Subject: RE: 485/APP/2023/128 - 18 THE BROADWALK
Date: Wednesday, 8 March 2023 at 17:09:18 Greenwich Mean Time
From: Matthew Taylor
To: Rhian Thomas
CC: Jas Phull, Rhian Thomas, Raj Sangha, peter@pjbplanning.co.uk
Attachments: image001.png, image002.jpg, image003.png, image244471.jpg, image181408.png, 18 The Broadwalk letter 080423.pdf, 2209 18 The Boardwalk - neighbouring building proximity sketch-A3-02.pdf

Please see attached a letter of response from our Planning consultant to your email (below) regarding application 485/APP/2023/128 for 18 The Broadwalk, Northwood.

Drawing No:
2209-PL-120

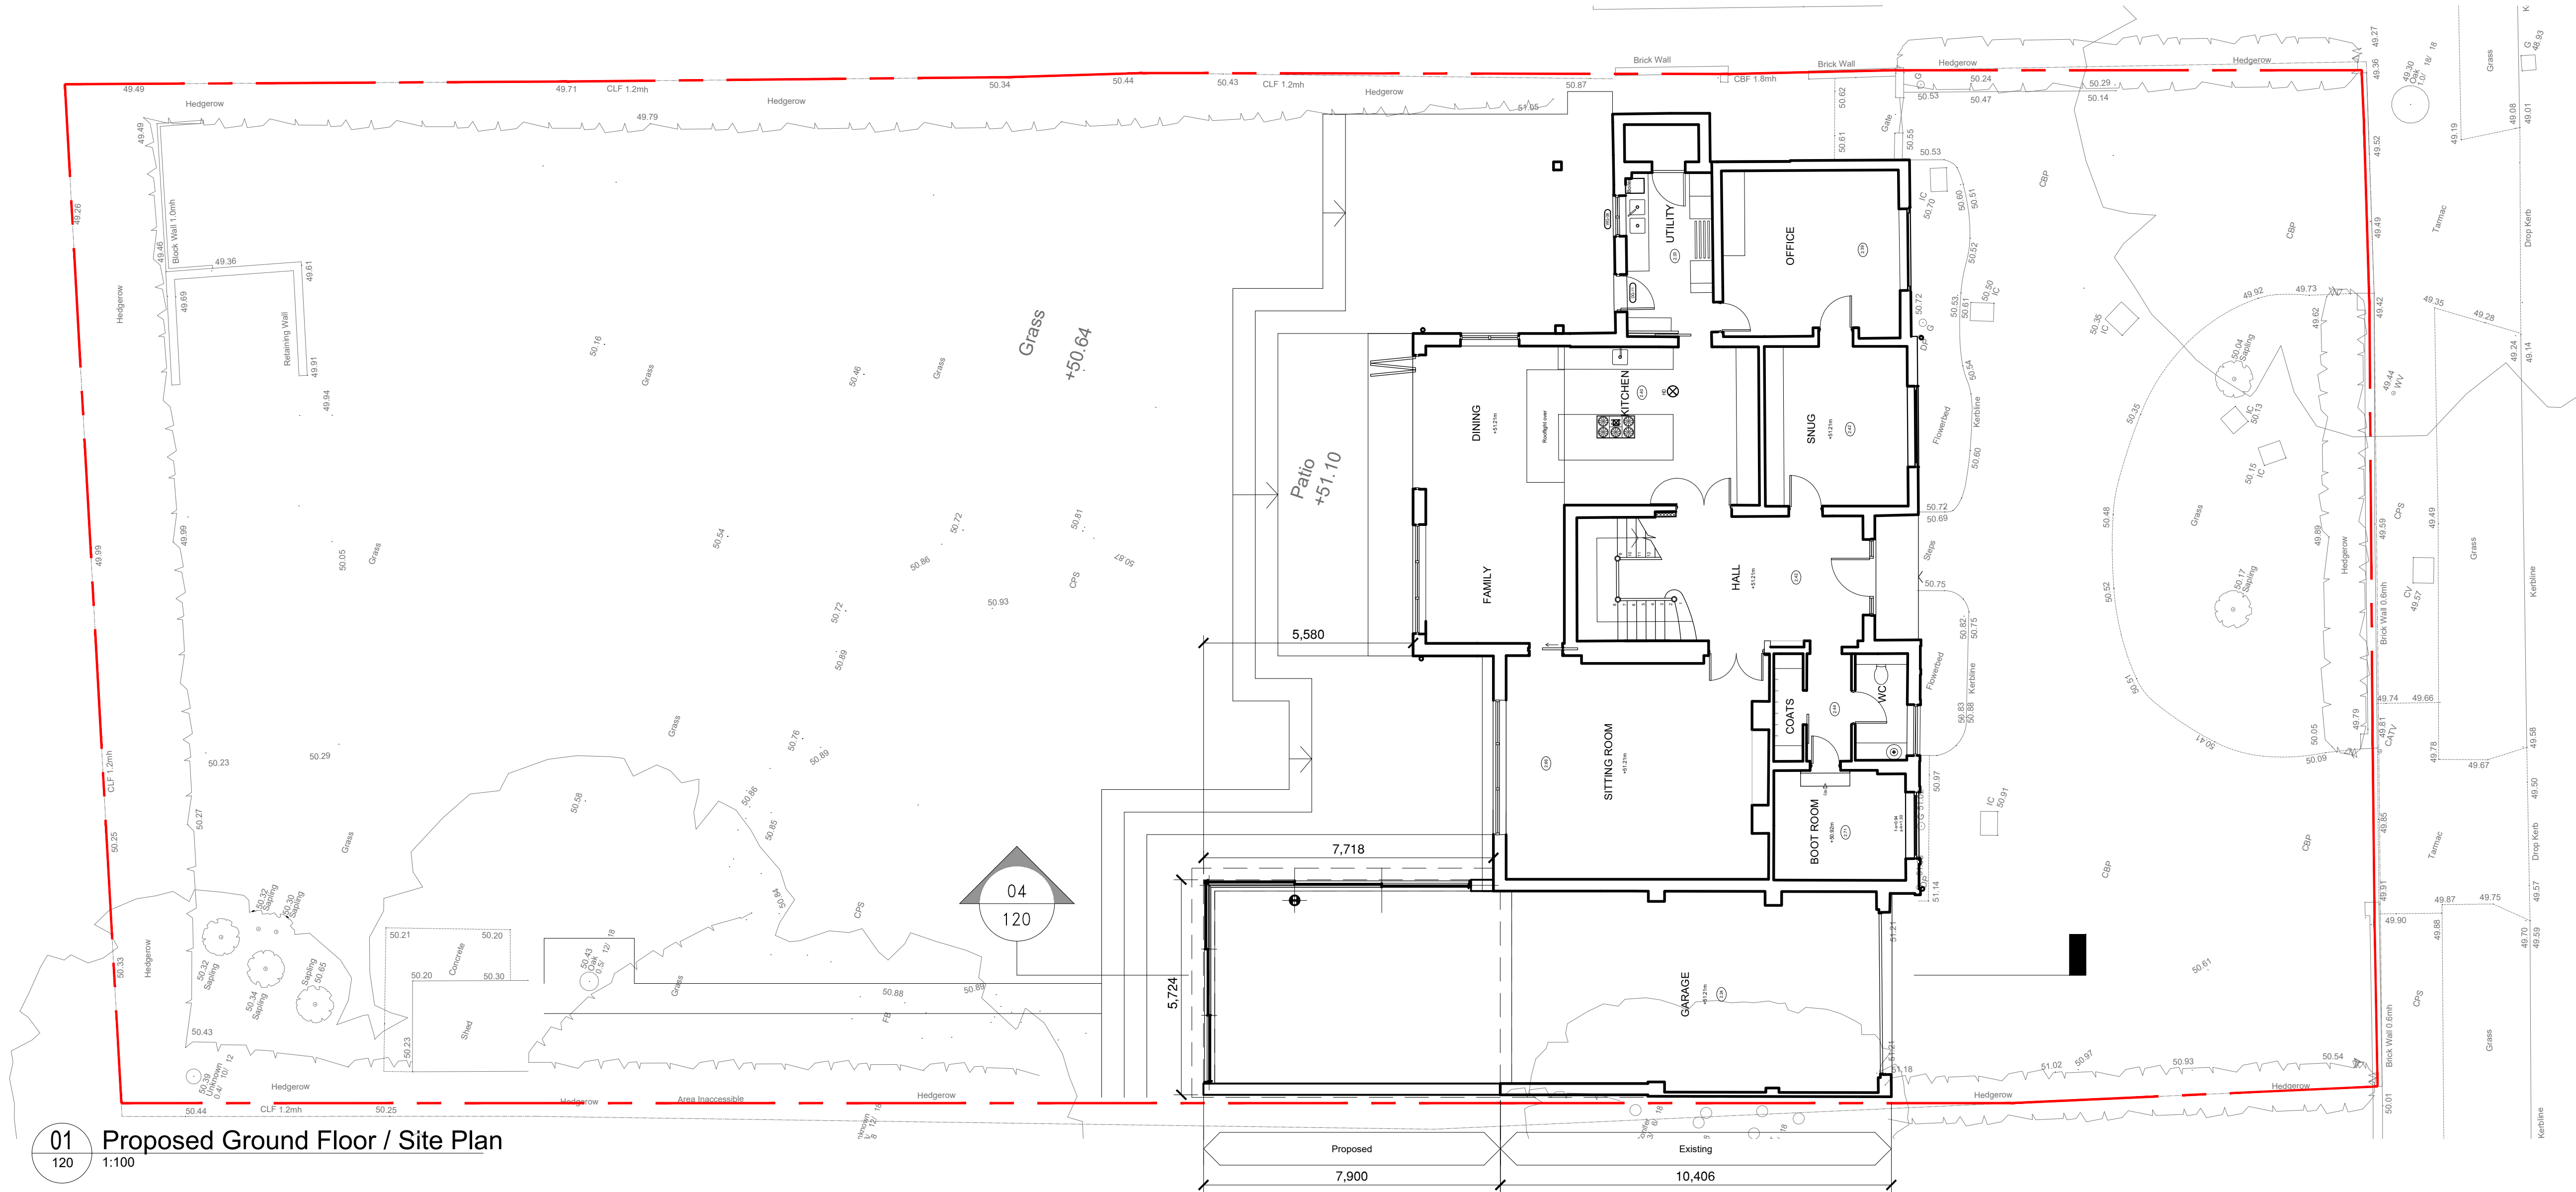
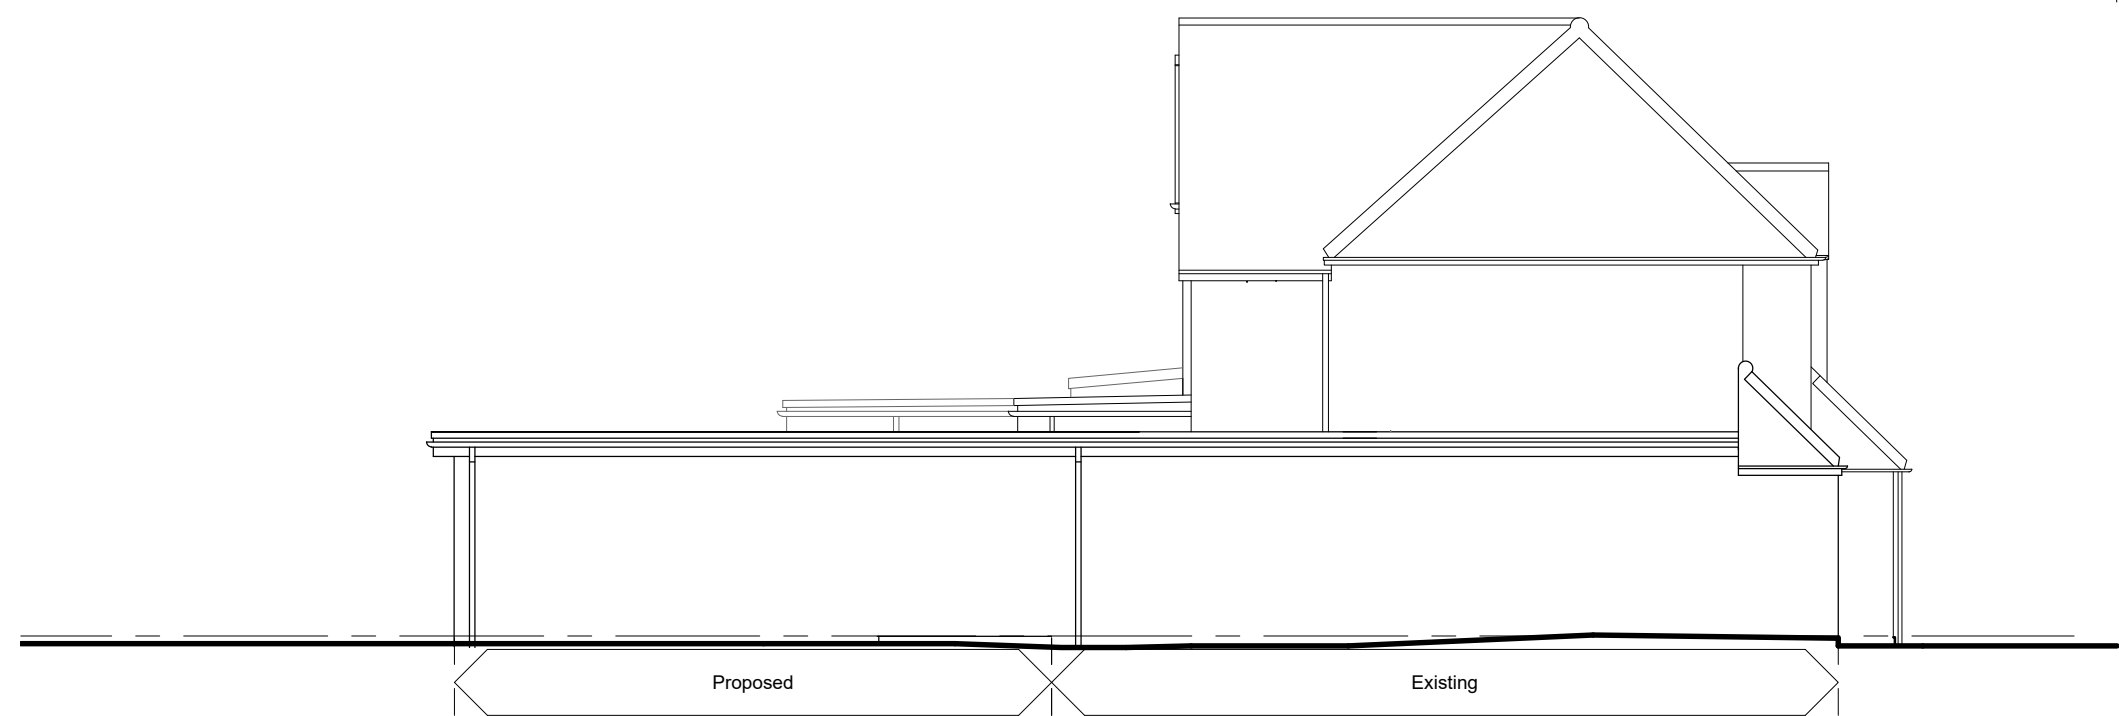
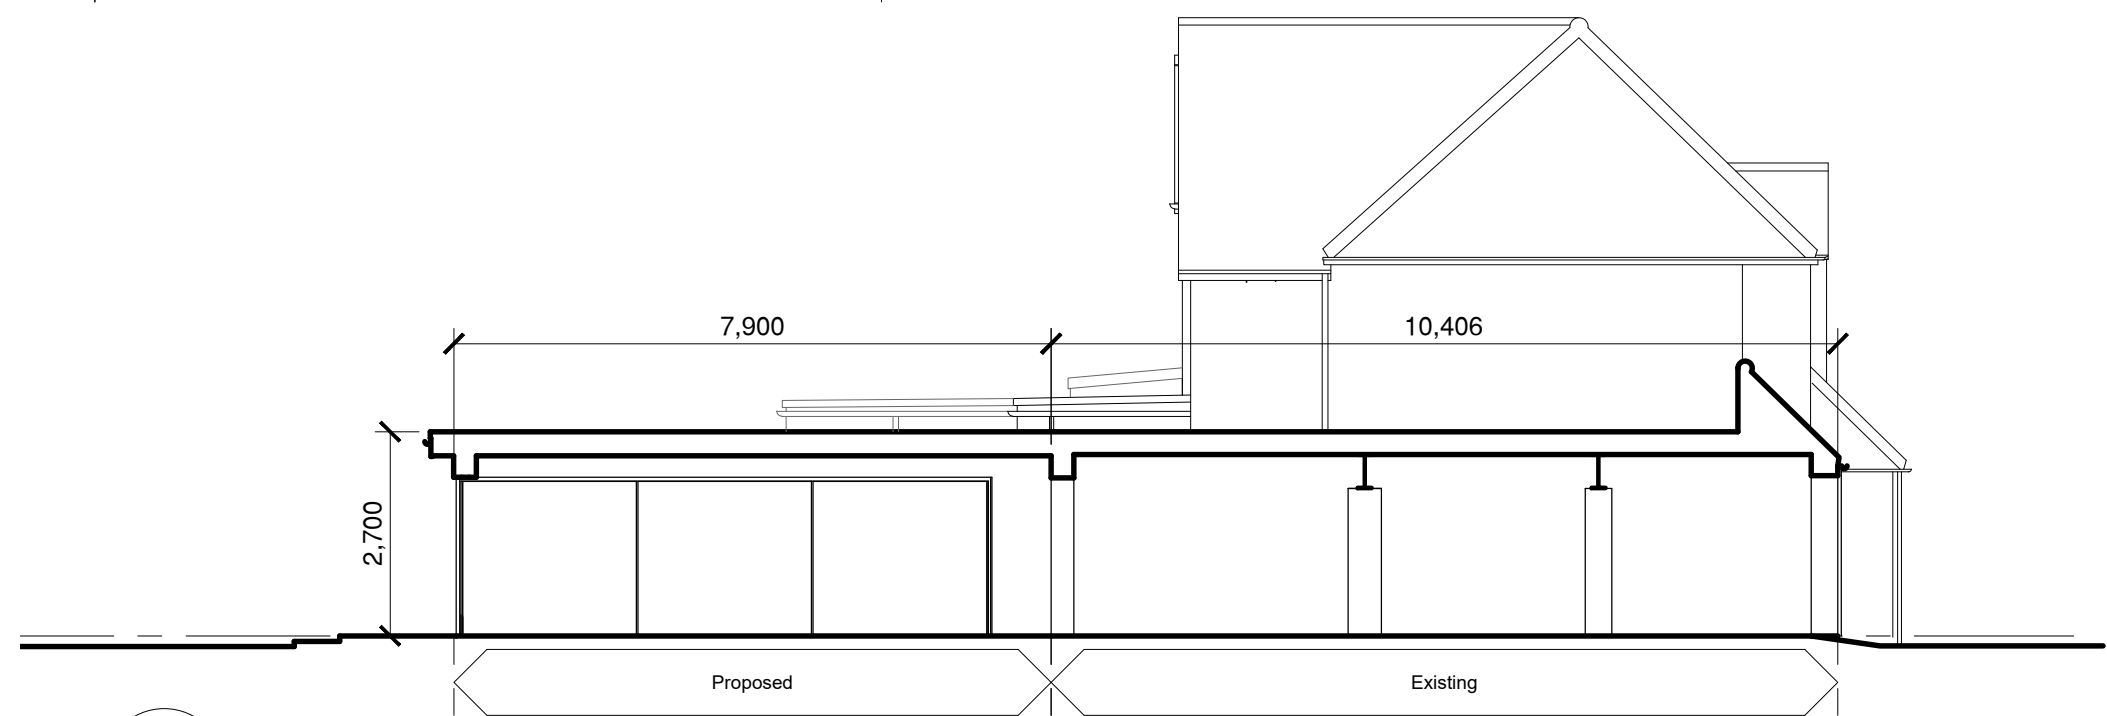
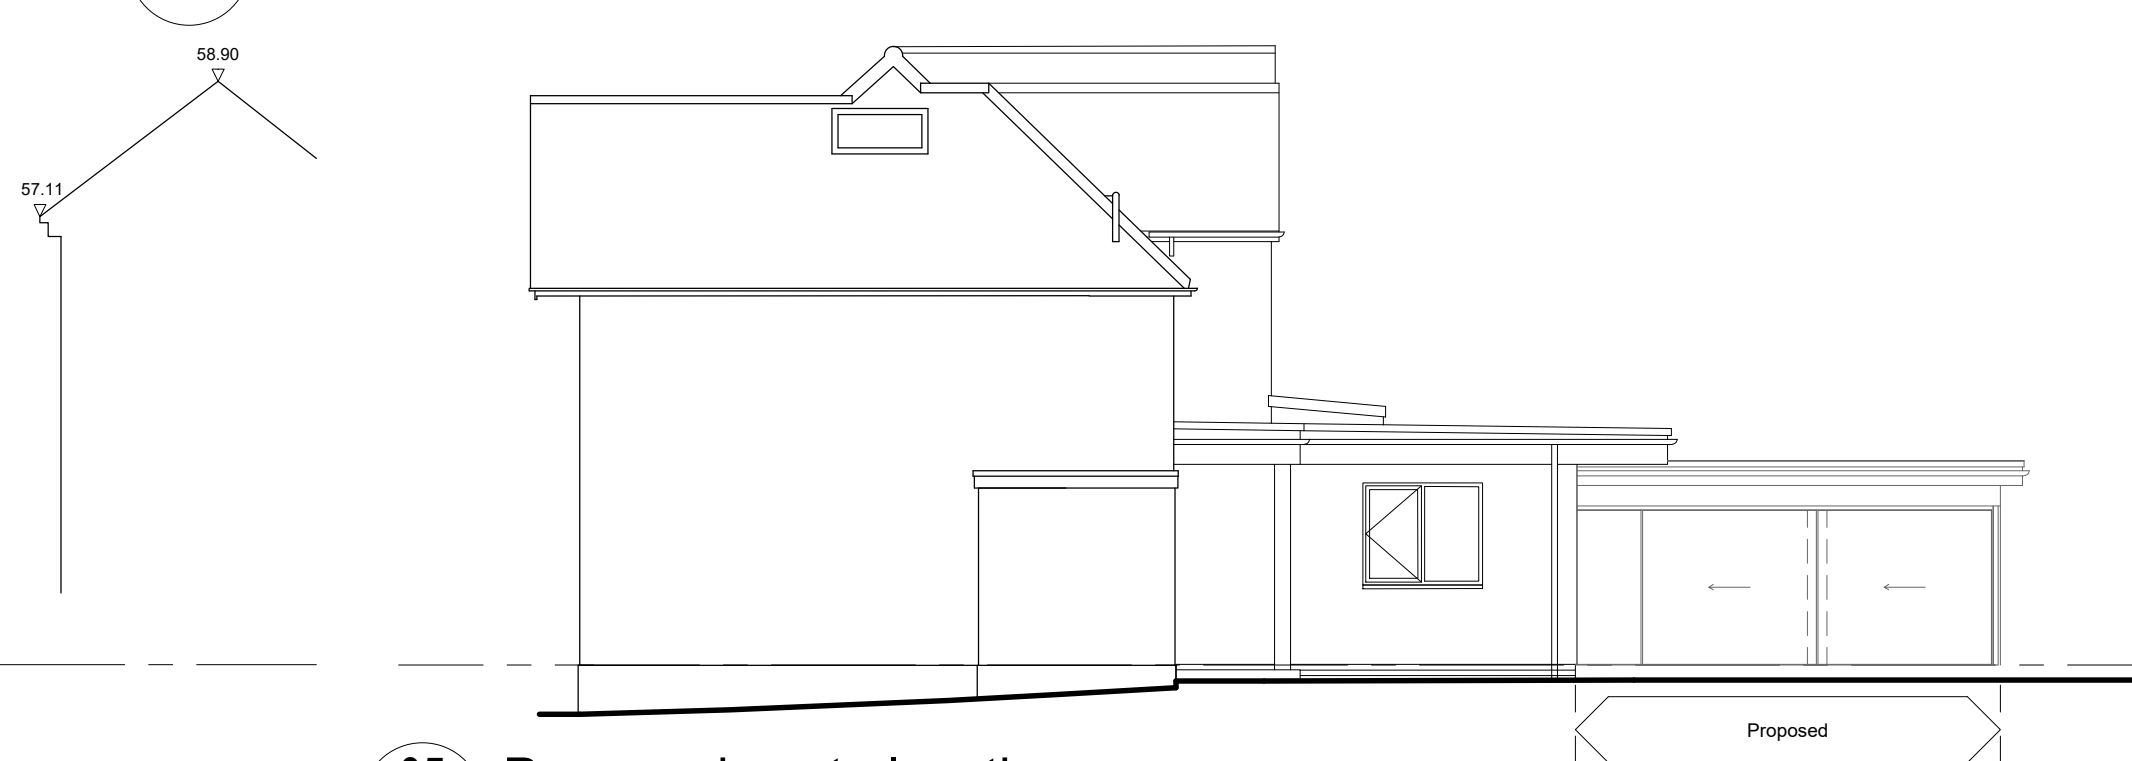
I've discussed the application in depth with my Team Leader and unfortunately we will be recommending the application for refusal due to the positioning right along the shared boundary, causing an unneighbourly addition, as well as being disproportionate to the dwelling.

Even with a reduced depth, we would not be happy to approve this extension due to the positioning.
